TREE CONSERVATION REPORT
ADDENDUM 2.1
71 Russell Ave

Tree Conservation Report Addendum submitted as
Partial Requirements for a Site Plan Control
Application, May 29, 2026

Tree Conservation Report Addendum

1 SITE PLAN
A1.0 SCALE 1" = 1'00"

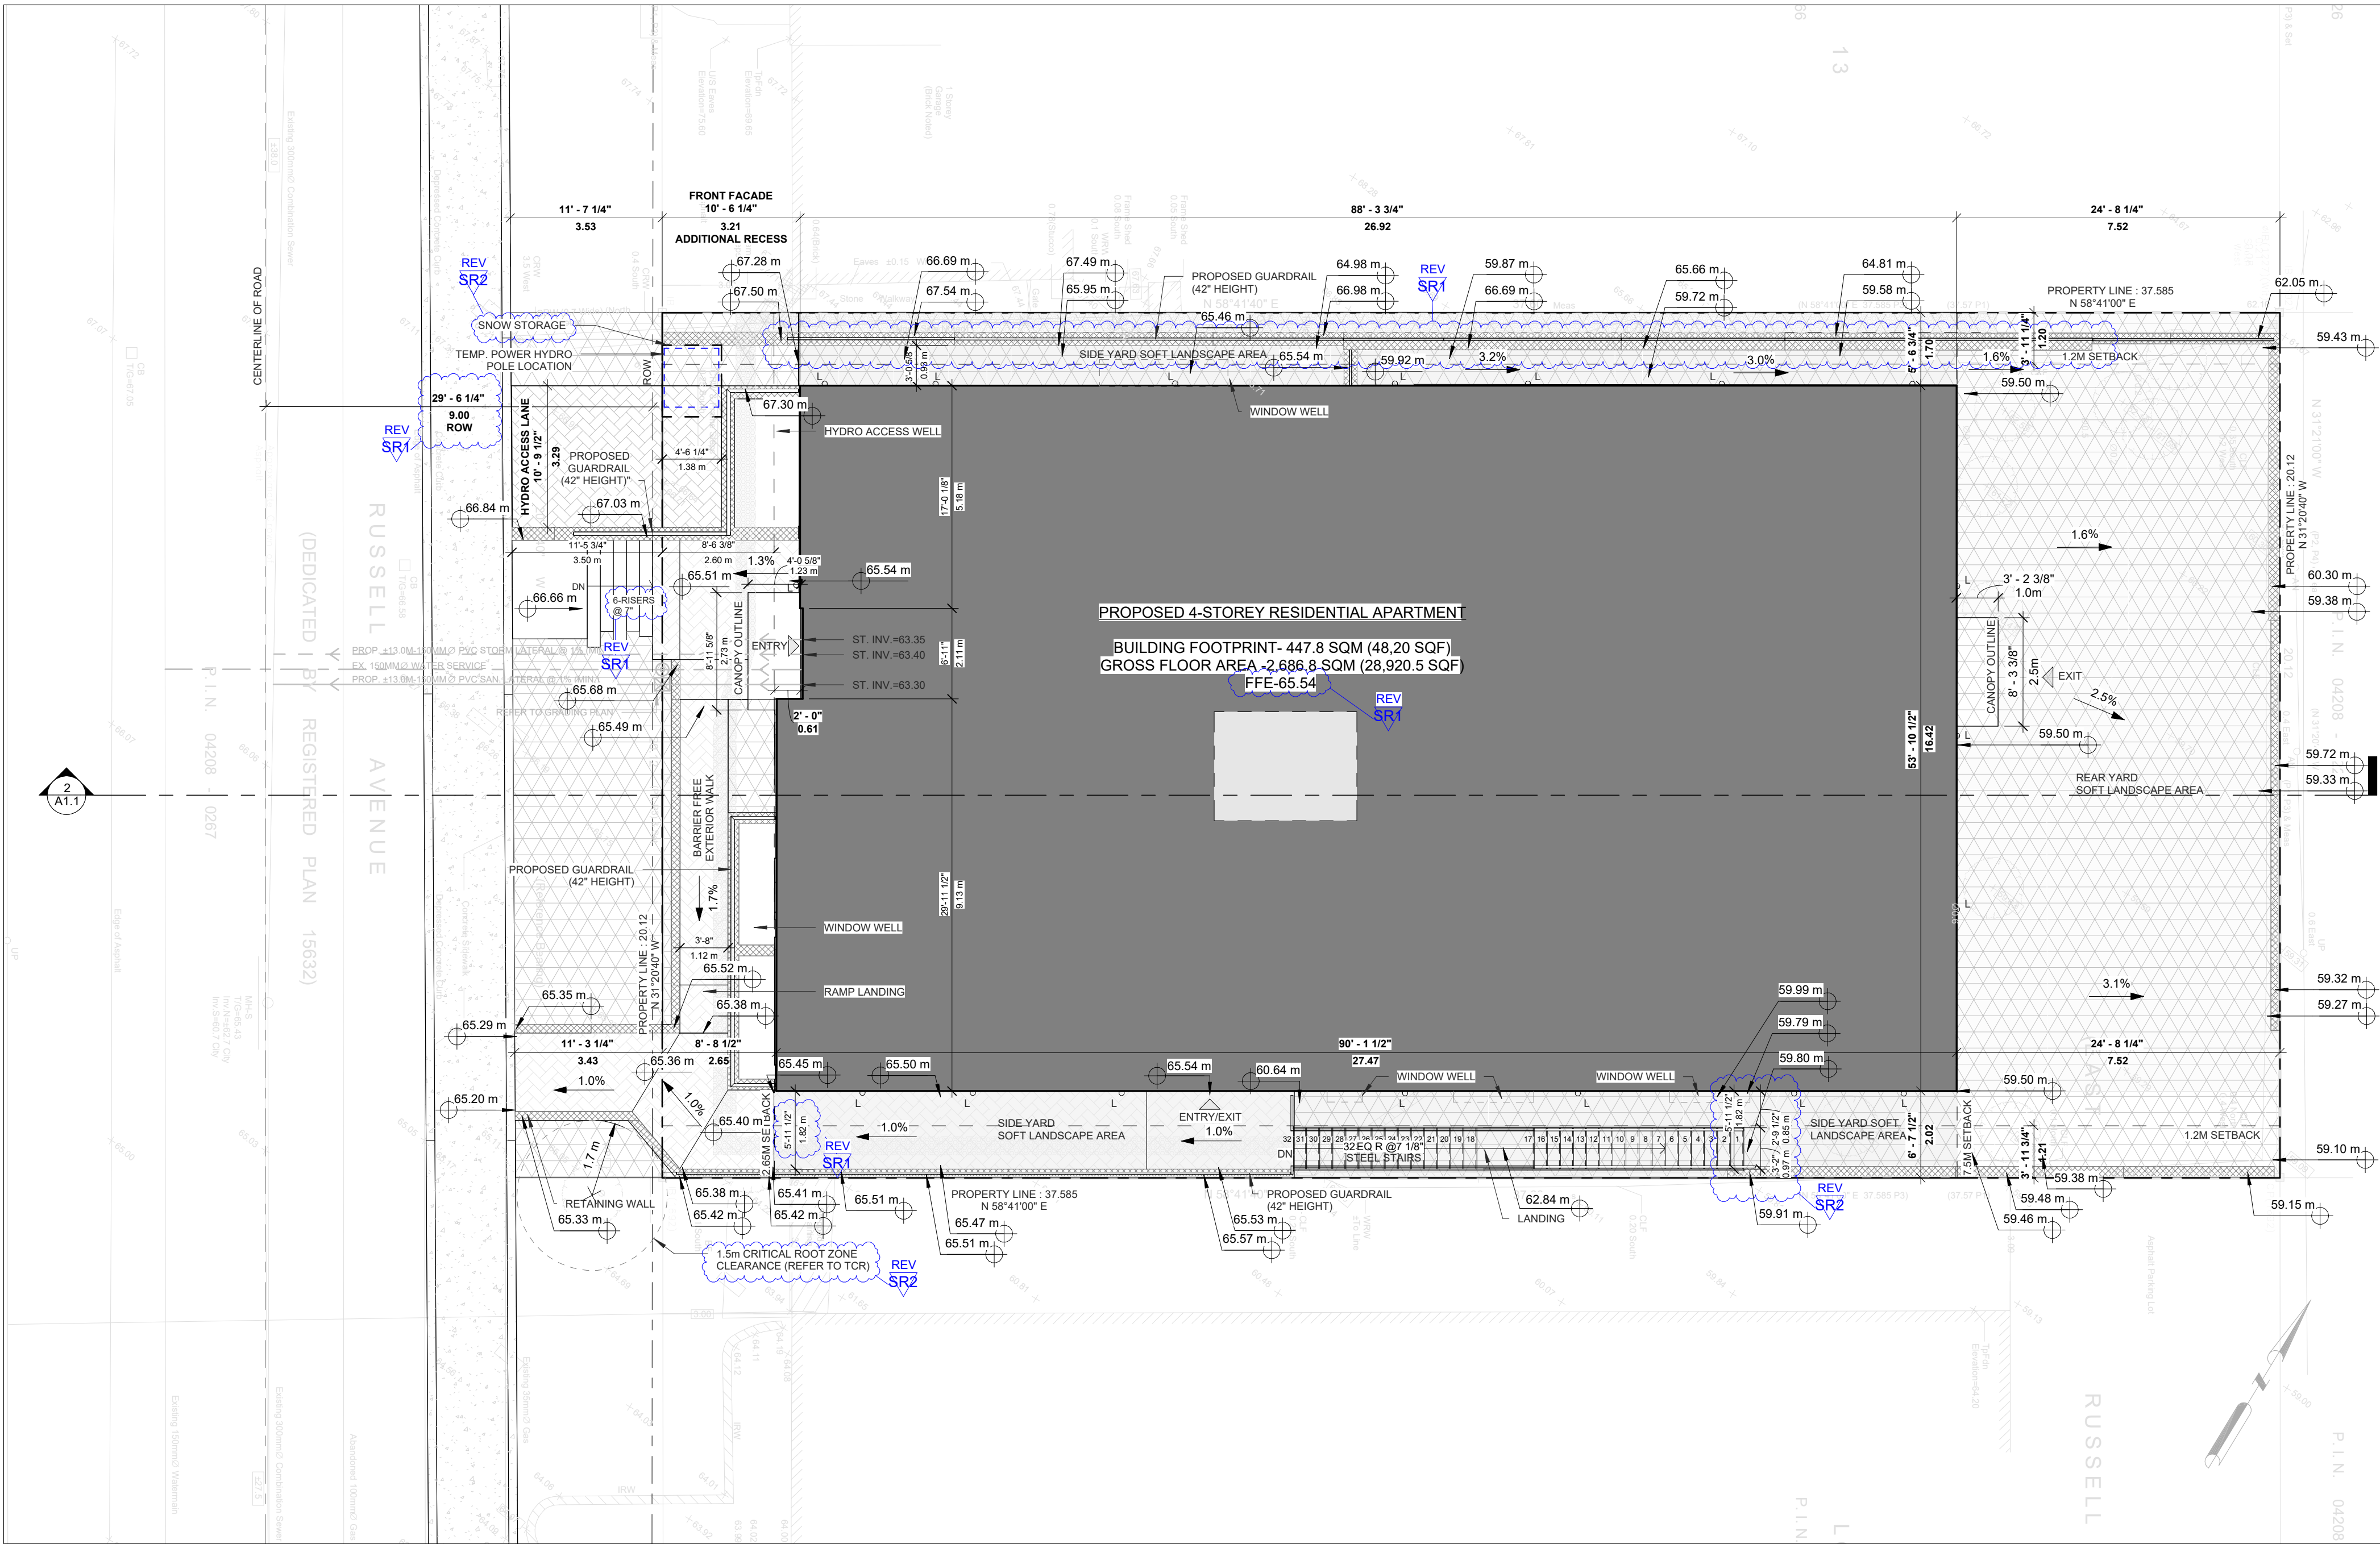
Comment# 107: There are significant tree implications associated with this proposed development. An updated Tree Conservation Report must be prepared by a Registered Professional Forester. The report must address:

- 4. The tree protection fencing for trees 10 and 11 overlaps with the proposed stairs and with a future talkway and curb for tree 1. This is unrealistic. Please address in the TCR and provide more details on the plan and how it can be executed as planned.

Tree 1: This updated report reflects changes that were made to the grading plan for the walkway to curve around the tree. The new walkway and retaining wall will be approximately 1.5 m from the edge of the tree trunk which should avoid impacting the structural integrity of the tree. The tree roots are to be pruned in advance of any excavation for the walkway and retaining wall and be completed by a certified arborist and/or city forestry staff. The same applies to the removal of any branches for the clearance of equipment on site.

Prior to any site works, protective fencing should be installed around the Tree Protection Area for tree 1 as indicated in the Tree Conservation Report map and maintained until all construction on site has been completed as per the City of Ottawa Tree Protection Specifications (March 2021).

DRAWING NAME:  
**RETAINING WALL SECTIONS**

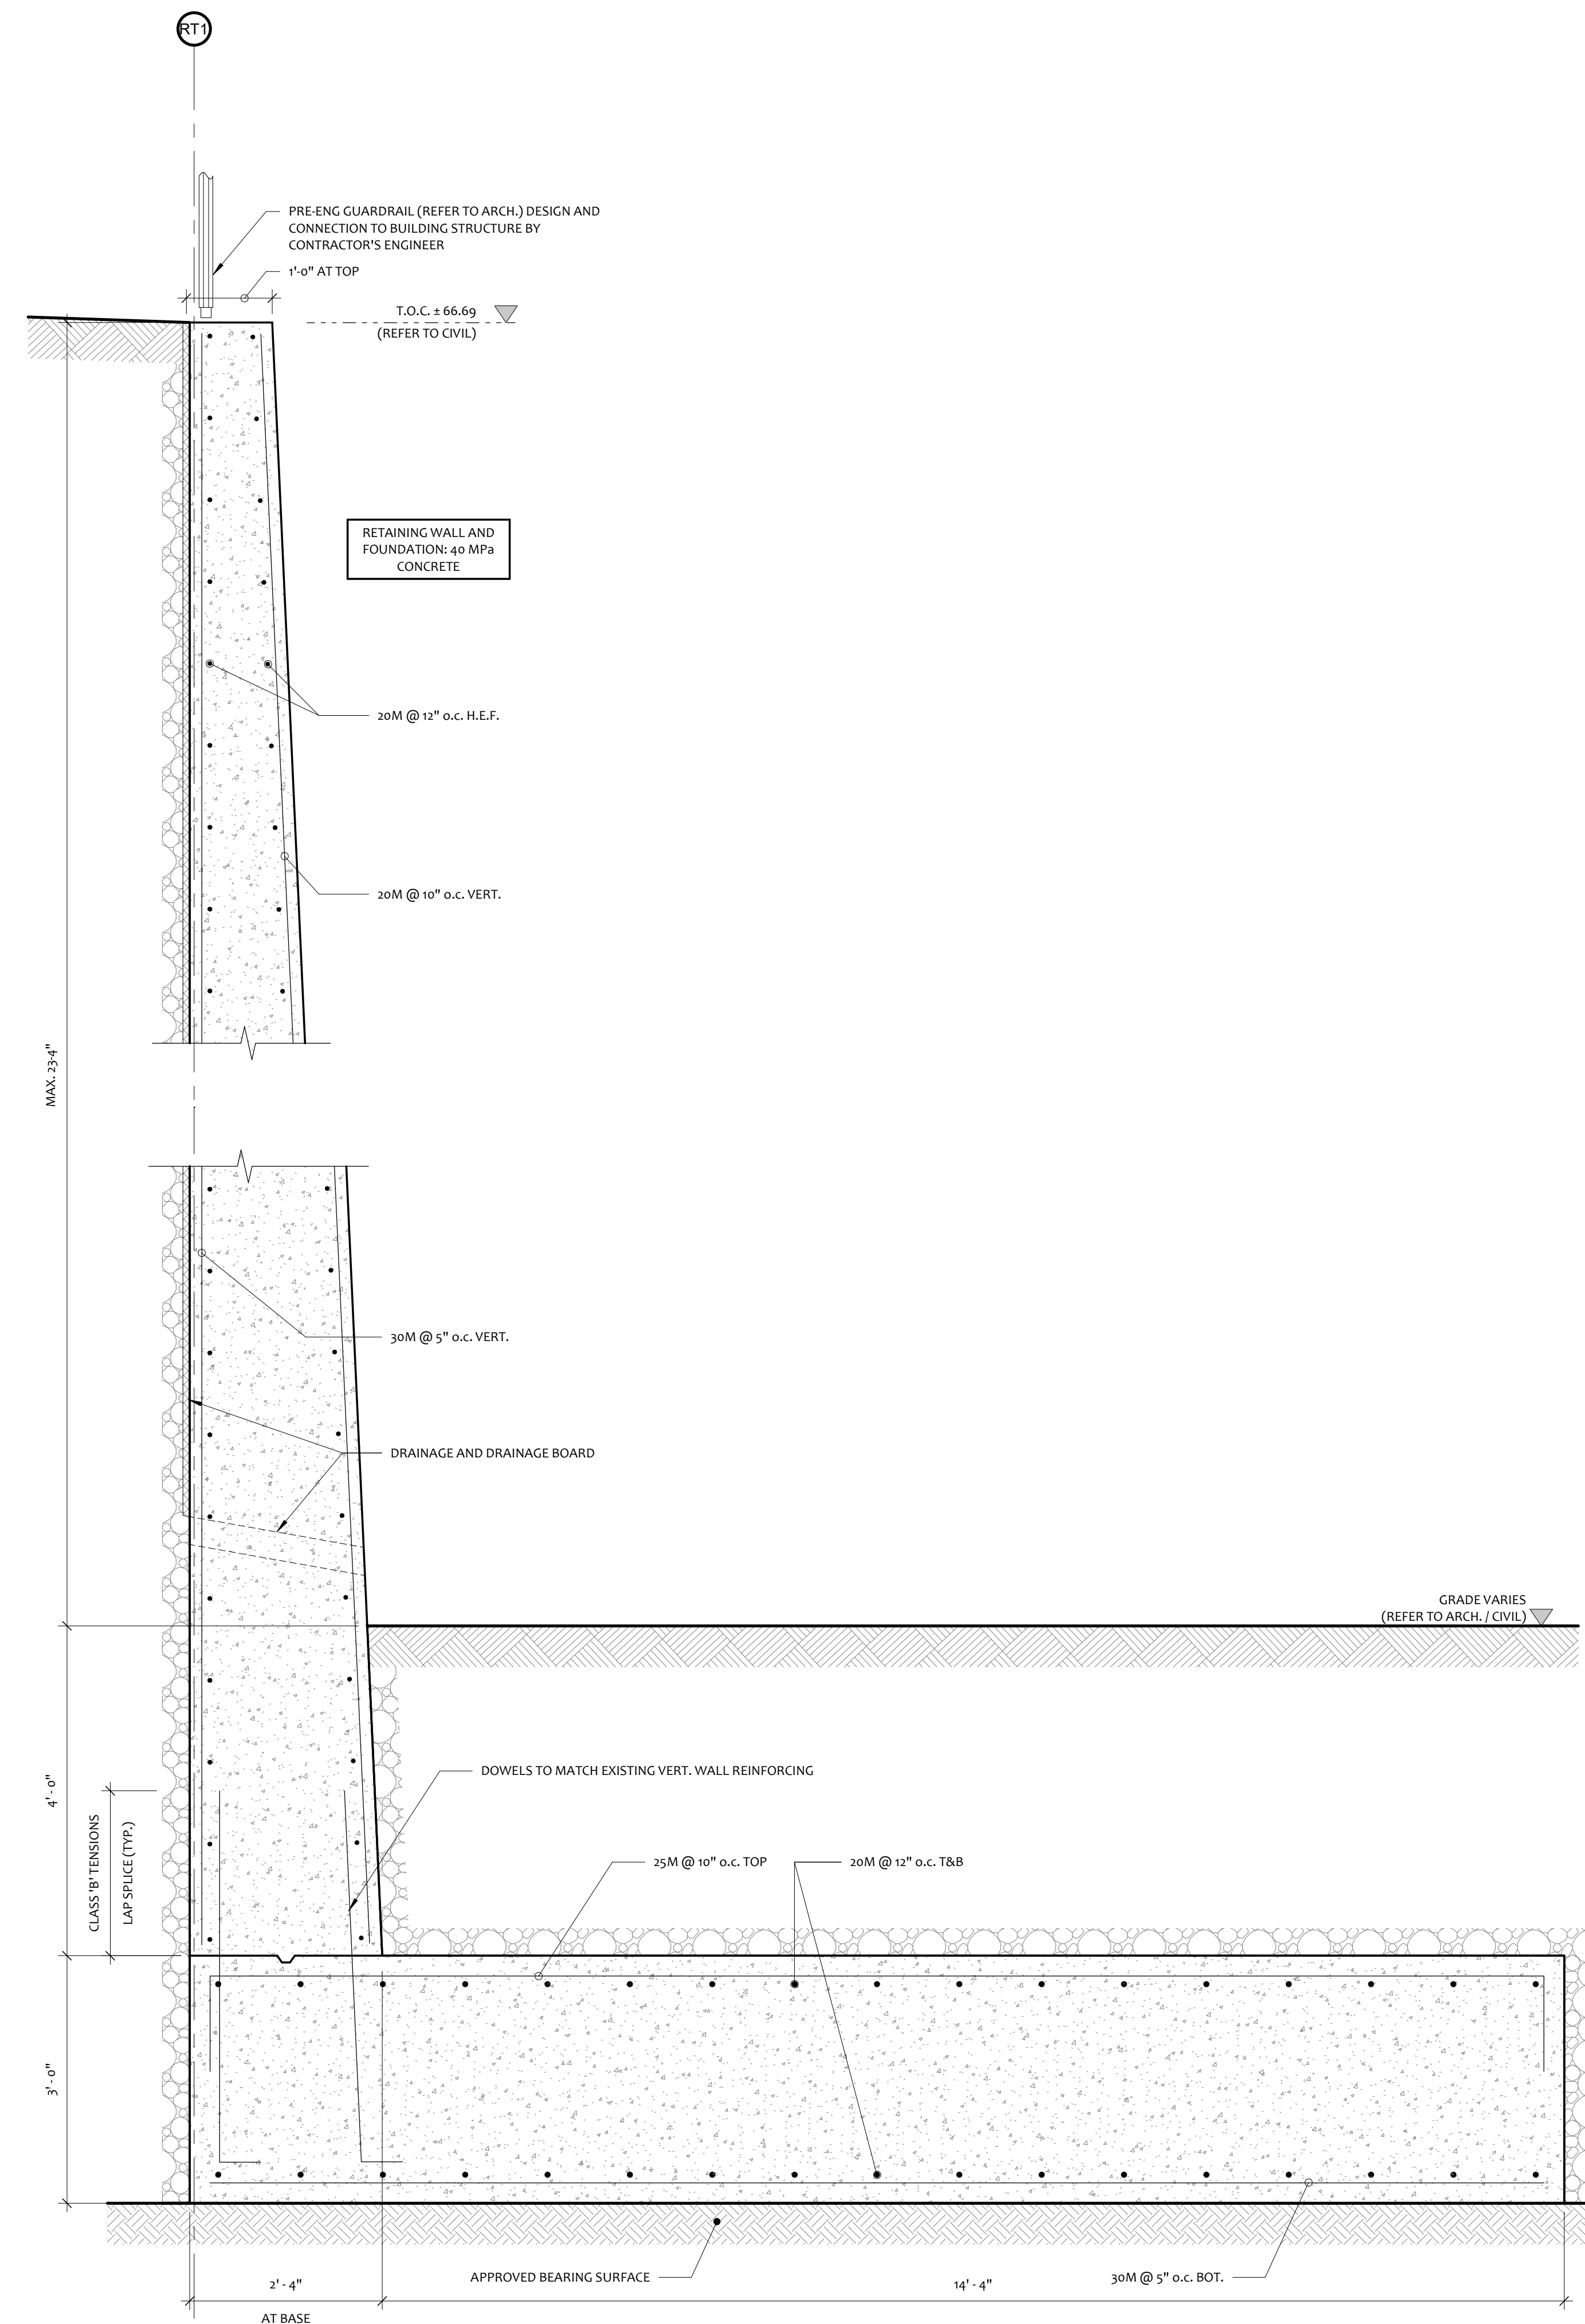
- 1. The retention plan for trees 1, 10 and 11 raises concern. Please provide more detail on the current growing condition of these trees, how much of the CRZs will be impacted by the proposed excavation and how far excavation is from the trunk of each tree. Address how the existing retaining wall beside trees 10 and 11 has influenced root growth and ensure the CRZs of these trees are accurately depicted. For tree 1, the proximity of the pavement and retaining wall is particularly concerning as it appears to be within the trees static root zone. There is concern over trees 1, 10 and 11 being made unstable by the extent of excavation/construction proposed in their proximity.

Tree 10: This tree is situated directly on the property line and will likely be impacted by the proposed development. While building excavation will utilize shoring, the construction of the new retaining wall requires a grade change exceeding 4 meters. Despite these impacts, the current project objective is to retain this tree during construction. The existing retaining wall will be replaced with shoring set approximately 20 cm closer to the tree. Soil in this critical area will be removed non-destructively via hydrovac exploration, concurrent with the retaining wall removal and shoring installation.

Following this exploratory excavation, the tree must be re-assessed to determine if any critical stabilizing roots will become compromised and confirm whether retention is feasible. A full tree risk assessment is recommended. If the tree is identified as a high risk at that time and the property owners decide to keep it, they assume all liability and risk associated with that decision. Due to the deep excavation, the fall distance and severity of a potential branch or whole-tree failure are increased, and workers below will have limited to no overhead protection until the new building frame is erected. Dendron assumes no responsibility for personal injury, property damage, or project delays resulting from the retention of this tree.
